CITY OF ALBUQUERQUE

June 8, 2017

**RE: Skilled Nursing Facility
1610 Renaissance Blvd. NE
Requested for 60 Day Temporary C. O. - Accepted
Engineers Stamp Date 5/5/16 (F16D017)
Certification Dated: 6/6/16**

ENGINEER'S SEAL	SKILLED NURSING FACILITY RENAISSANCE CENTER	DRAWN BY DY
	GRADING AND DRAINAGE PLAN	DATE 5/05/16
	TERRA WEST, LLC 5571 MIDWAY PARK PLACE NE ALBUQUERQUE, NM 87109 (505) 858-3100 www.tierrowestllc.com	2014088-GRE
JOEL D. HERNANDEZ P.E. #17893		SHEET # C2
		JOB # 2014088

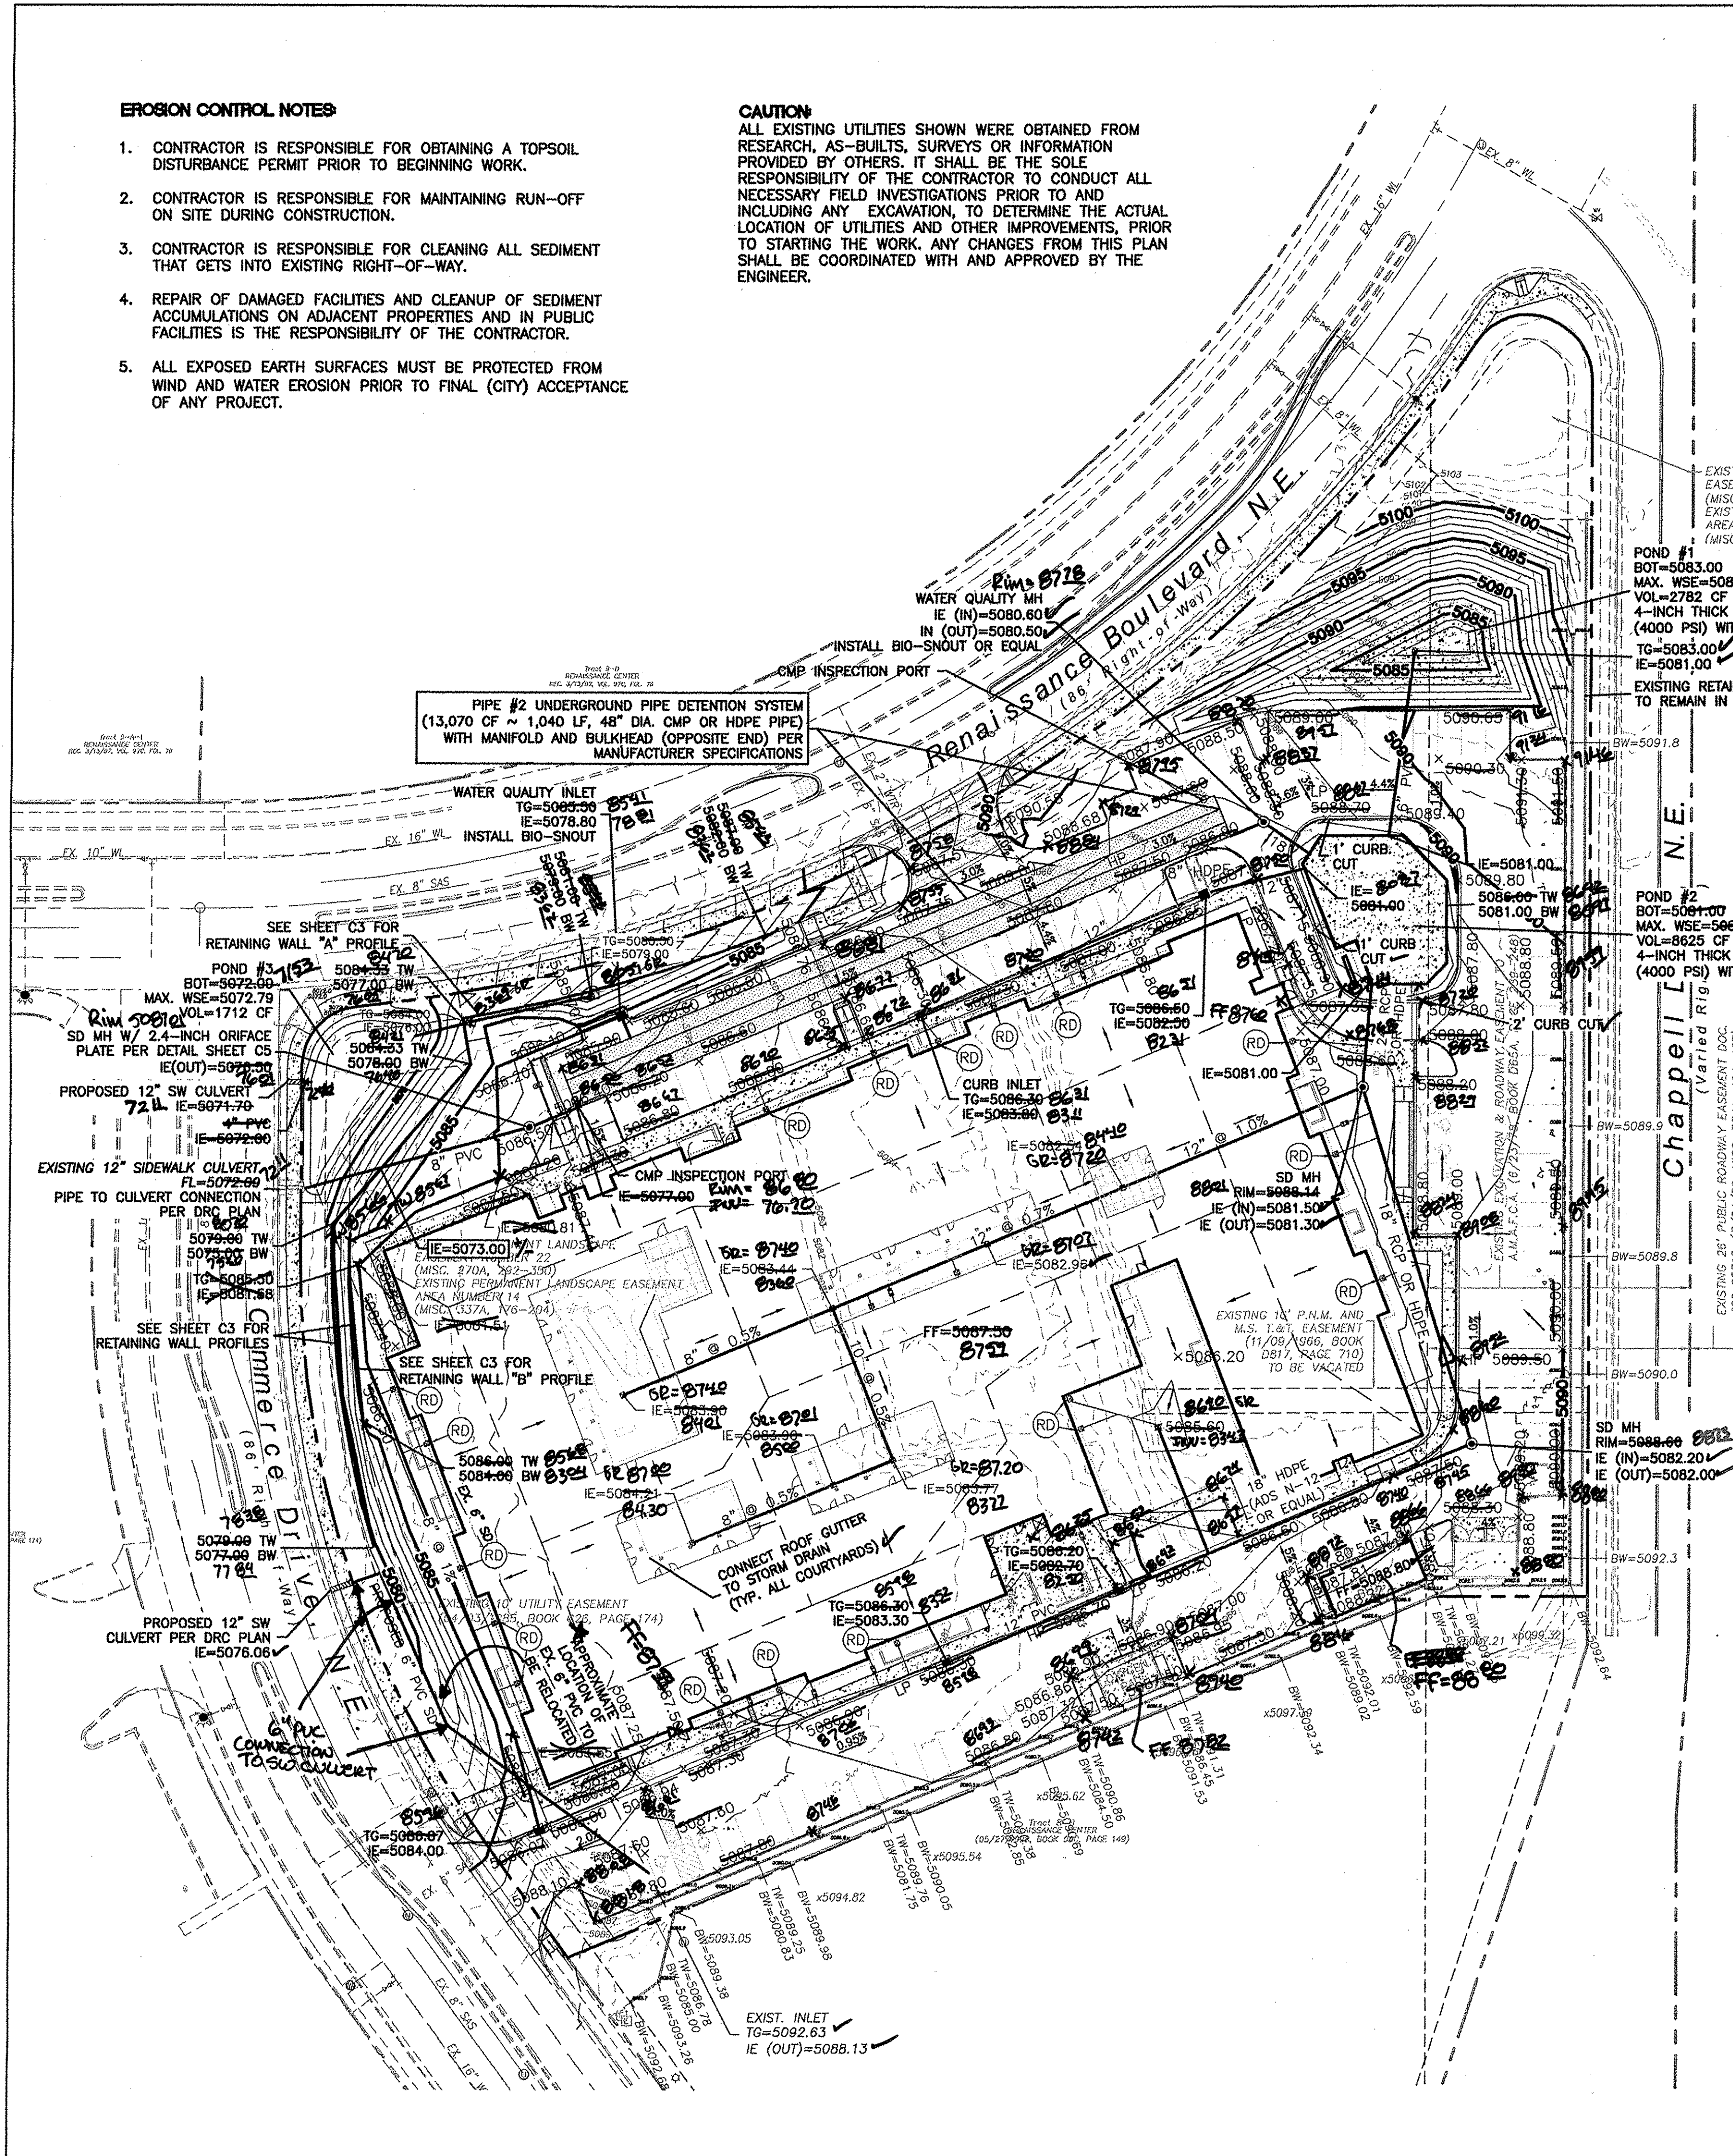
- Provide sheet C5 with certification for SD MH at NW corner of lot.
- Clarify Proposed 6" PVC SD line at SW corner of lot that appears to go nowhere.
